**District:** Cherwell

**Application no:** 16/00453/DISC

**Proposal:** Discharge of Conditions 5 (Landscaping), 9 (Contaminative Desk Study). Partial discharge of conditions 8 (play ares/open space), 14 (surface water scheme), 17 (location of all compounds and plant storage) and 18 (wheel washing facilities) of 13/01811/OUT.

**Location:** Phase 5 West of Wellington Road and Adjacent to Dow Street, Upper Heyford.

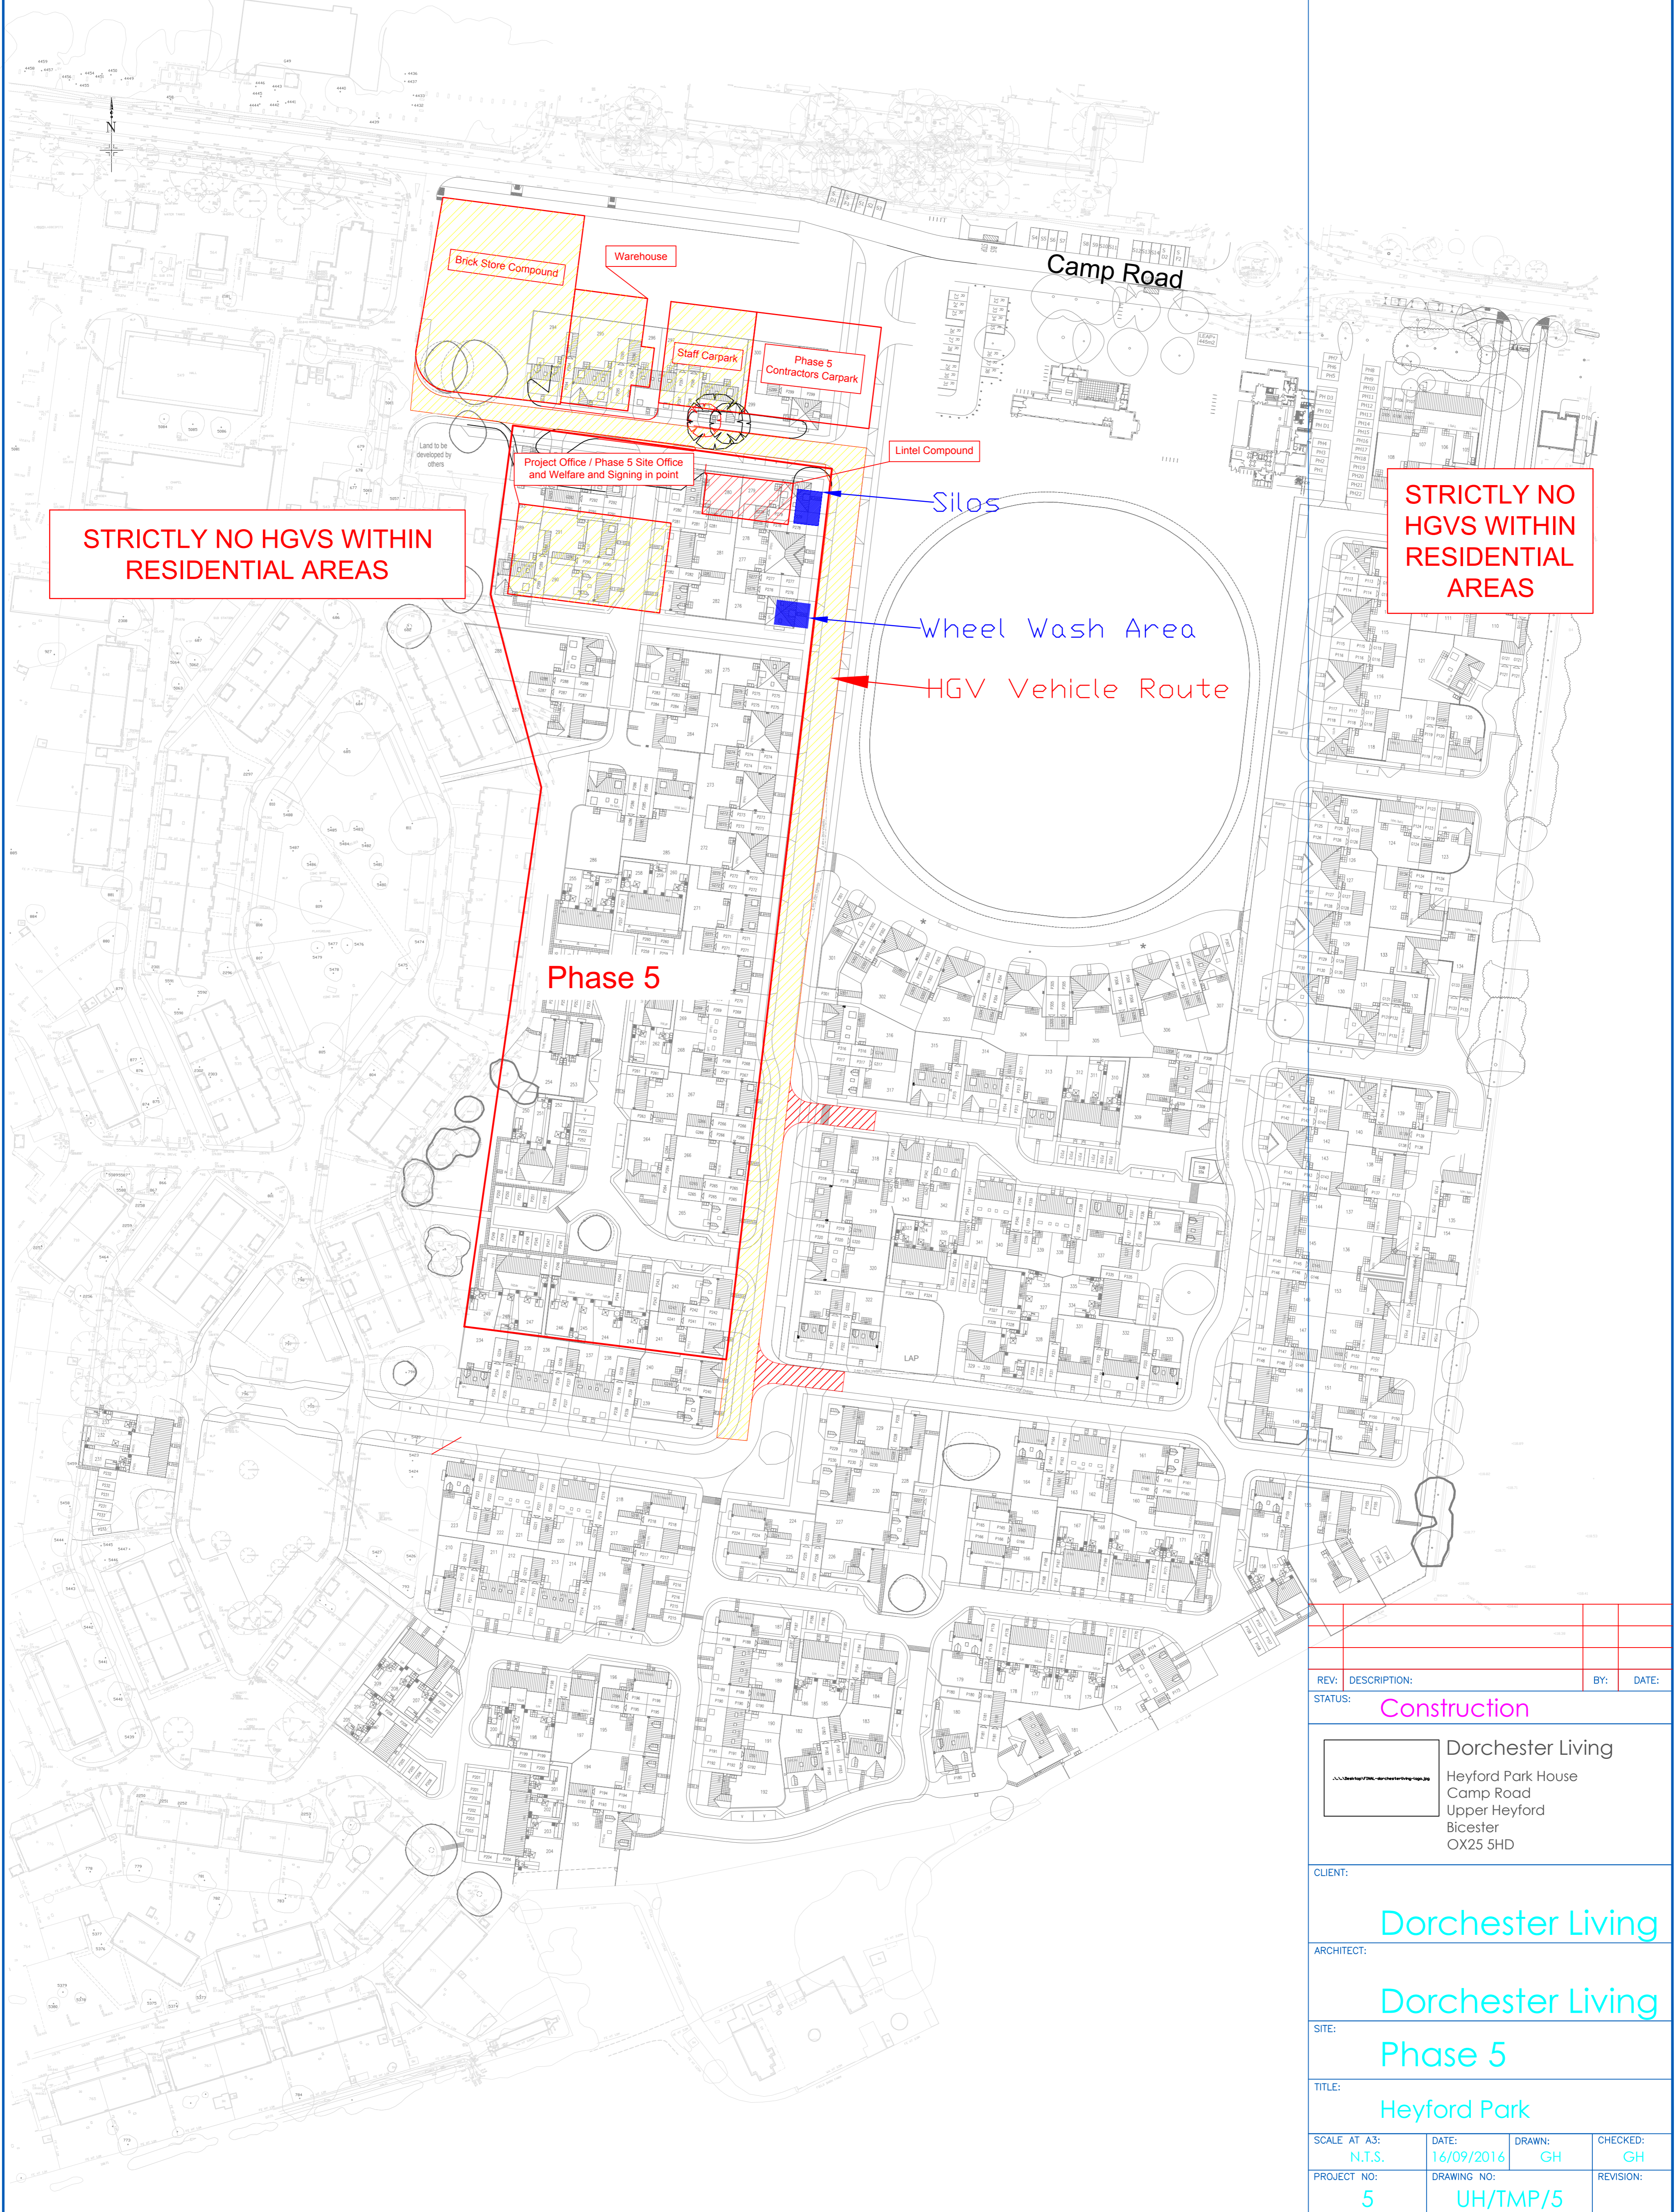
The Construction Compound & Access Statement and drawing No.UH/TMP/5 are both acceptable. **No objection.**

The location of the wheel washing facilities as shown on drawing No.UH/TMP/5 is acceptable. **No objection.**
